Applicant: Silver Beach LLC & Elizabeth Baum

Address: 83 Wellwood Rd

Permit # - 2014 - 01059

CHECK-LIST AGAINST ZONING ORDINANCE

REVISIONS:
 DATE: MAY 5, 2014
 PROJECT No.
 DRAWN BY:
 CHECKED BY:
 SCALE: AS NOTED
 SHEET TITLE:
SITE LAYOUT PLAN

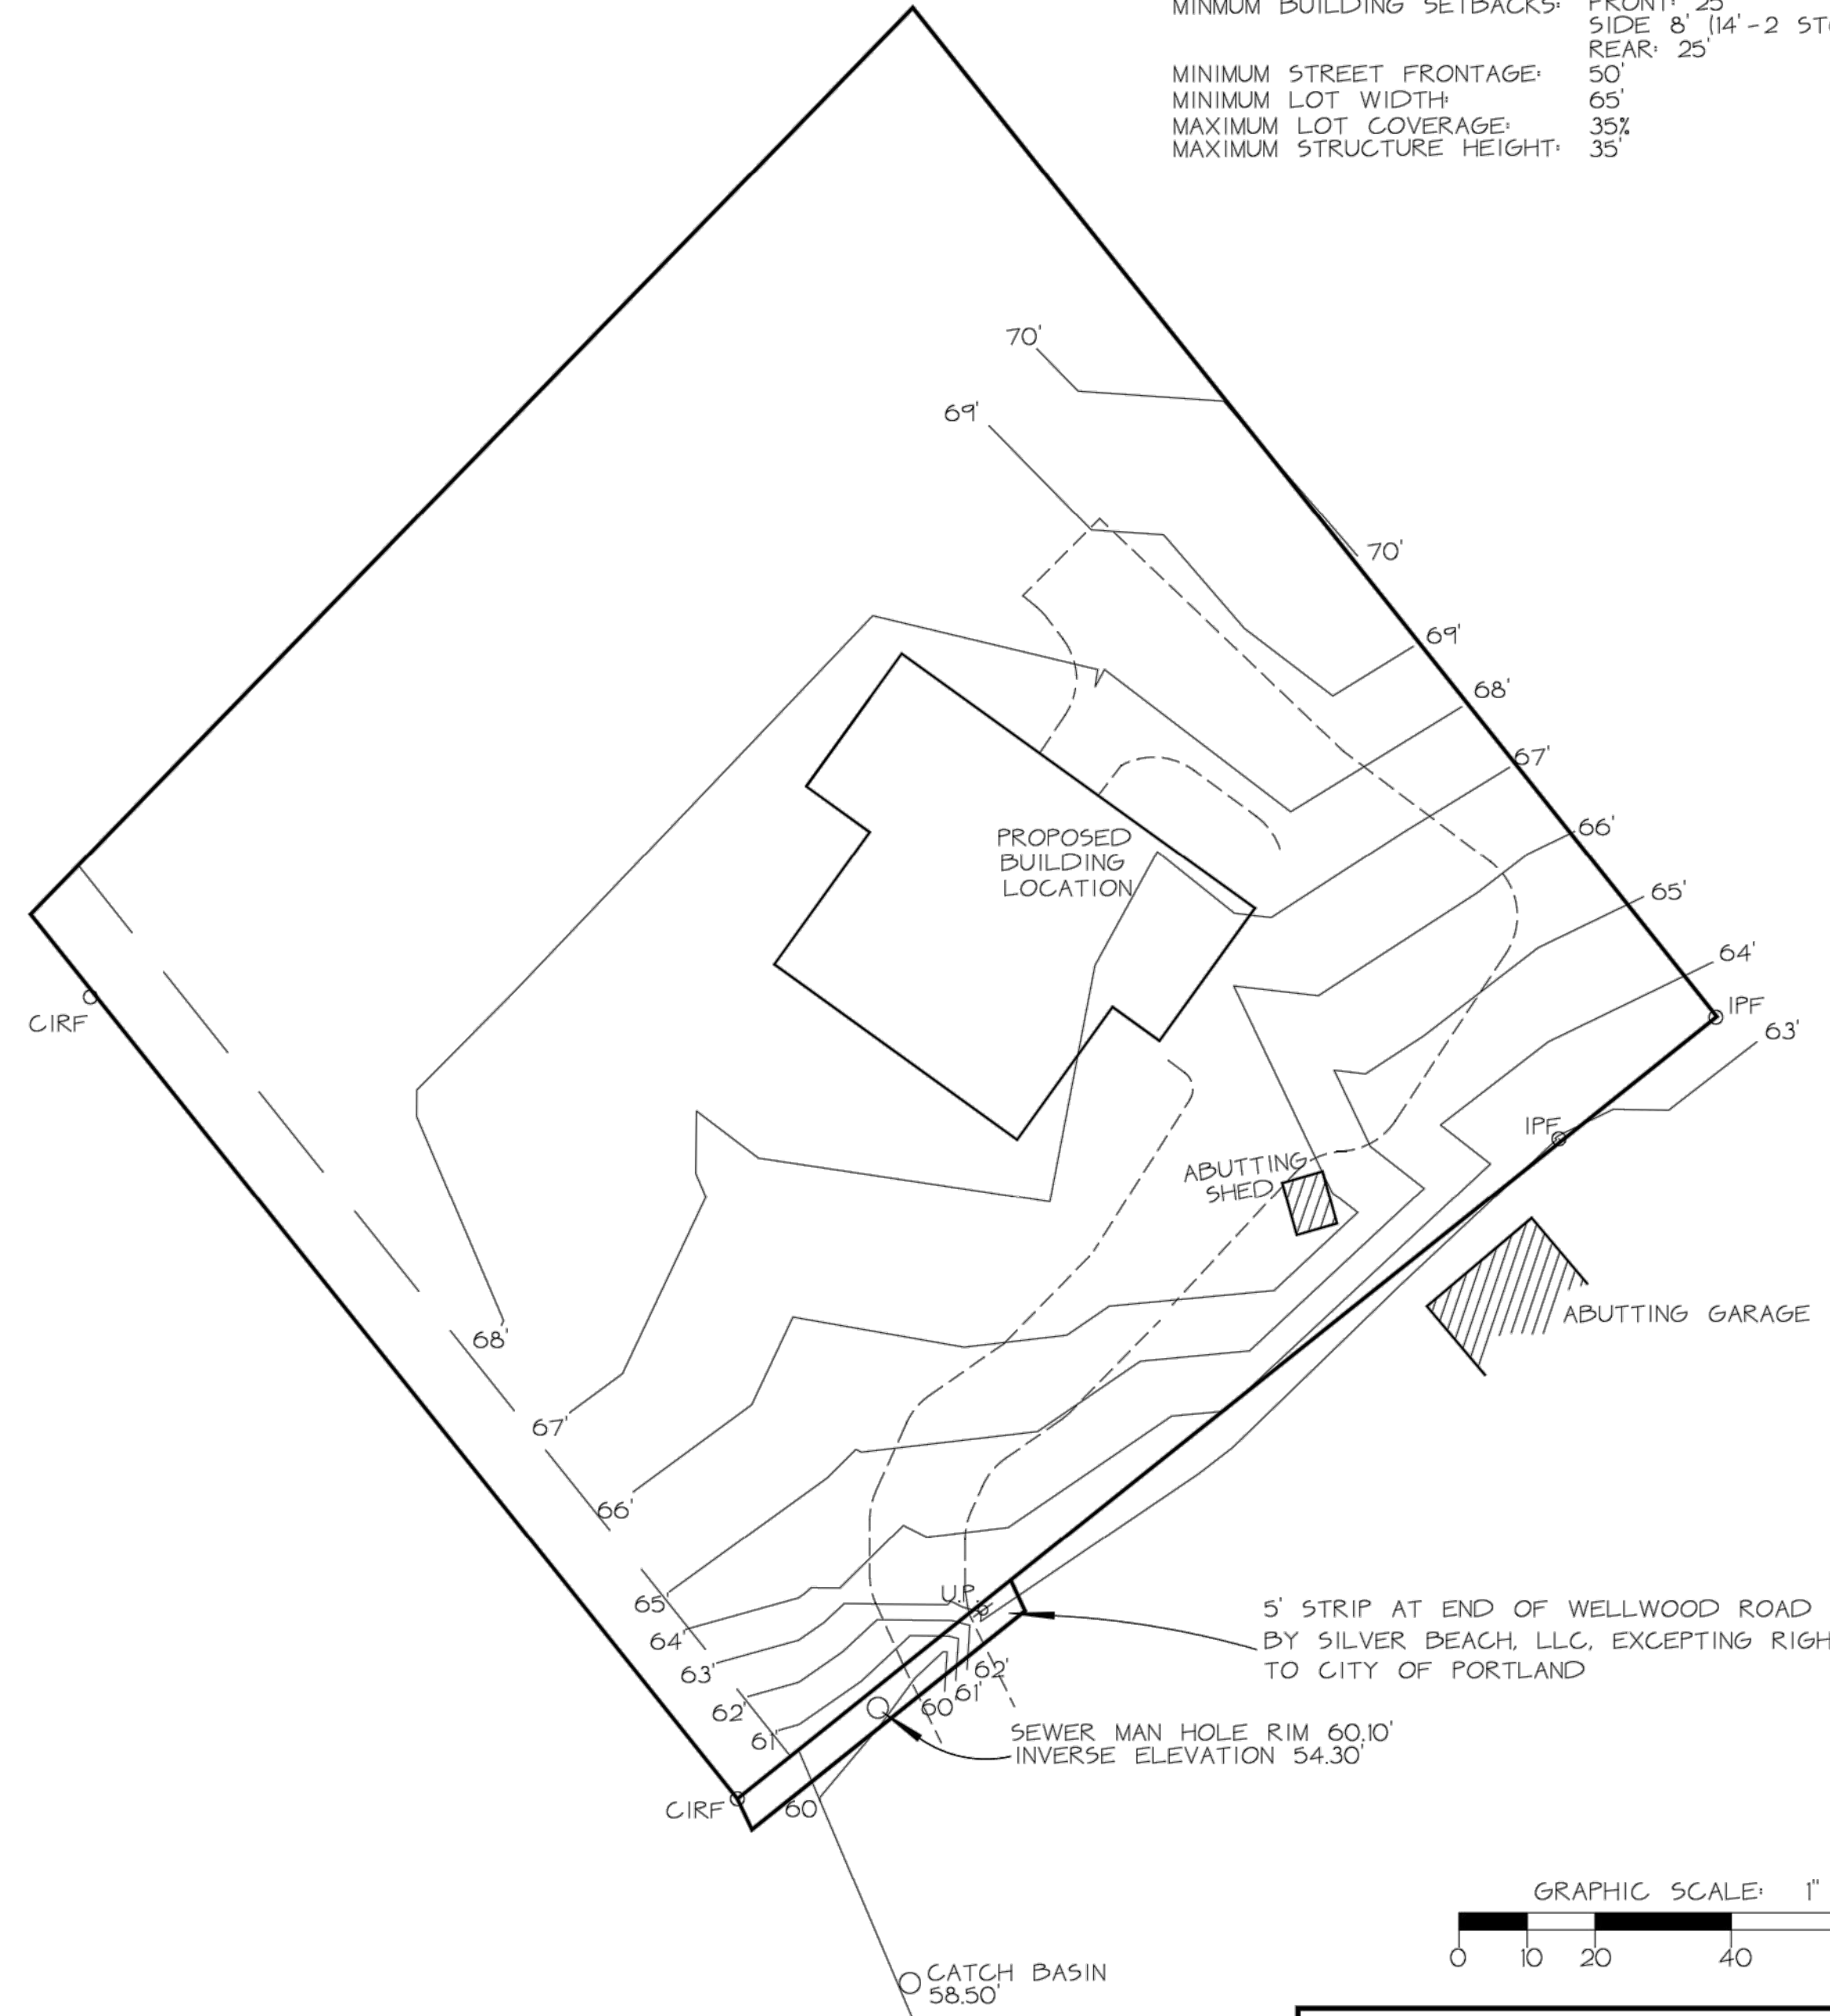
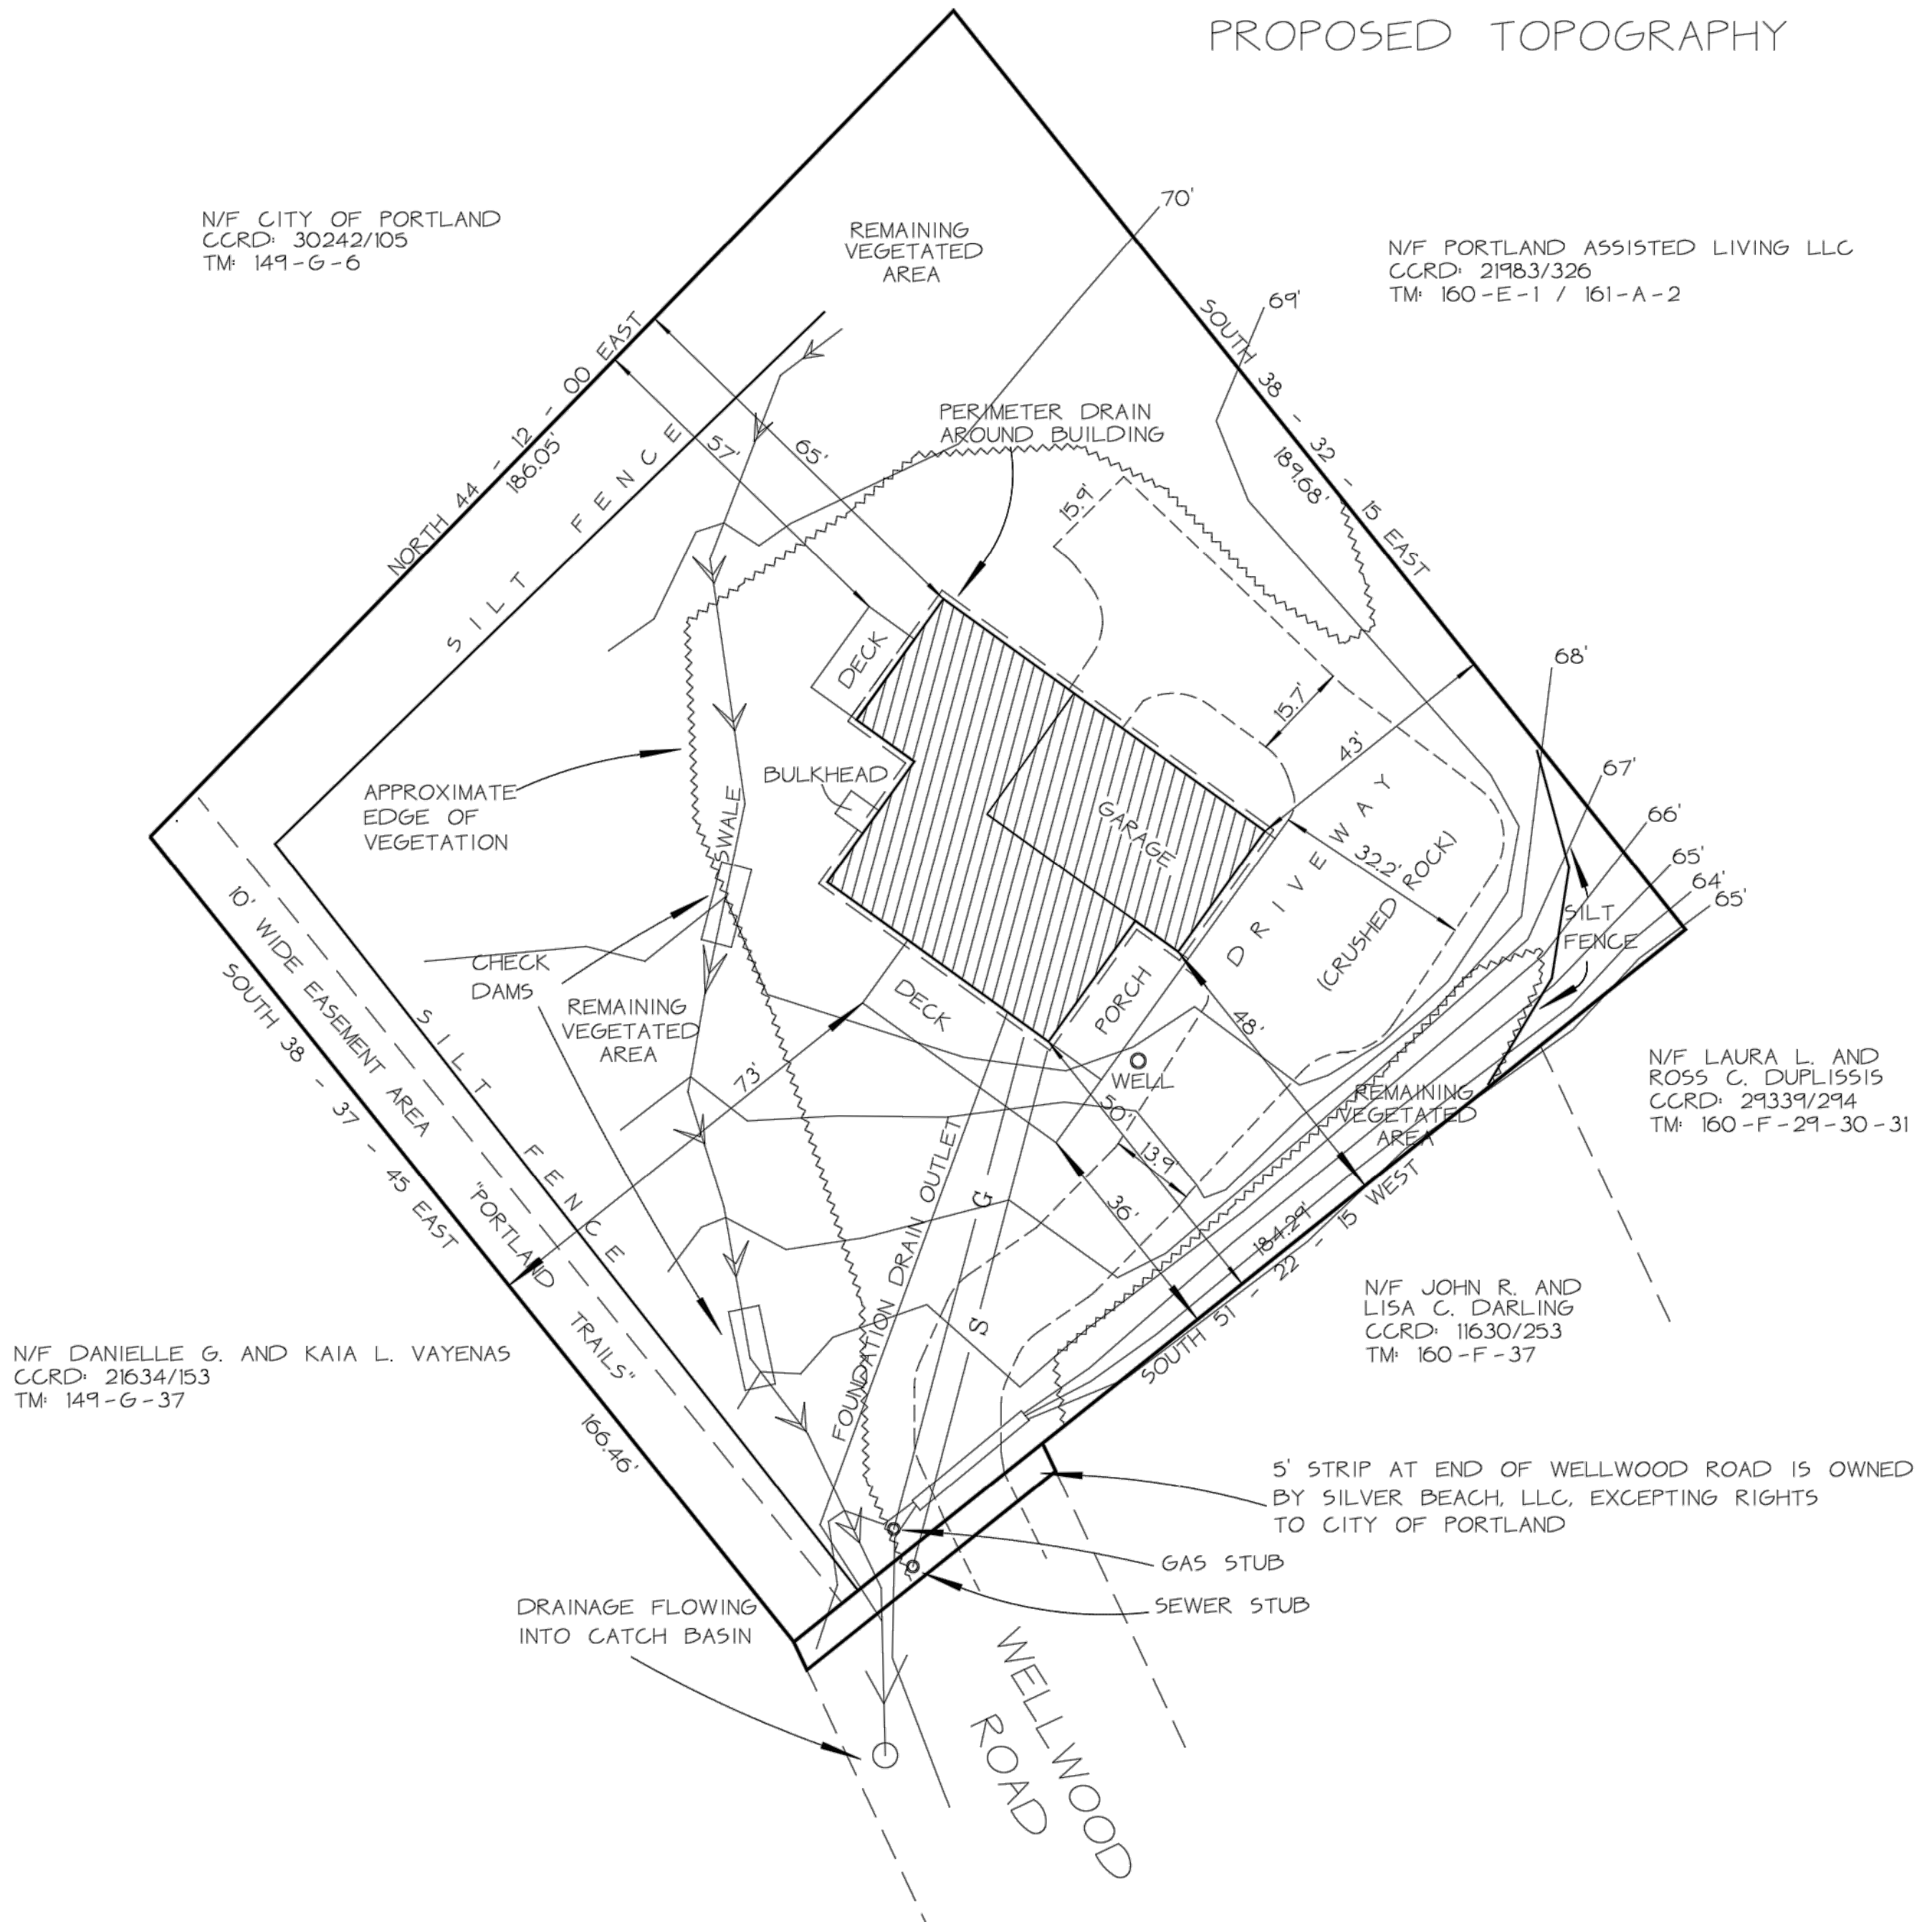
Front Yard - 25' min - 35.5' scaled to corner of deck (OK)

Rear Yard - 25' min - 65' to back corner
- 60' to possible deck or porch (OK)

Side Yard - two-story 14' min - 79' scaled on left OK
- 43' " " right OK

Width of Lot - 65' min - 184.6' scaled (OK)

* Height - 35' max - sides @ 32' bridge (OK)

Lot Area - 6700 sq ft - 33,092 sq ft given - OK

garage/ADU	45x24	=	1080
deck	24x64	=	1536
porch	37x12	=	444
	23x8.5	=	195.5
		=	3255.5 sq ft (OK)
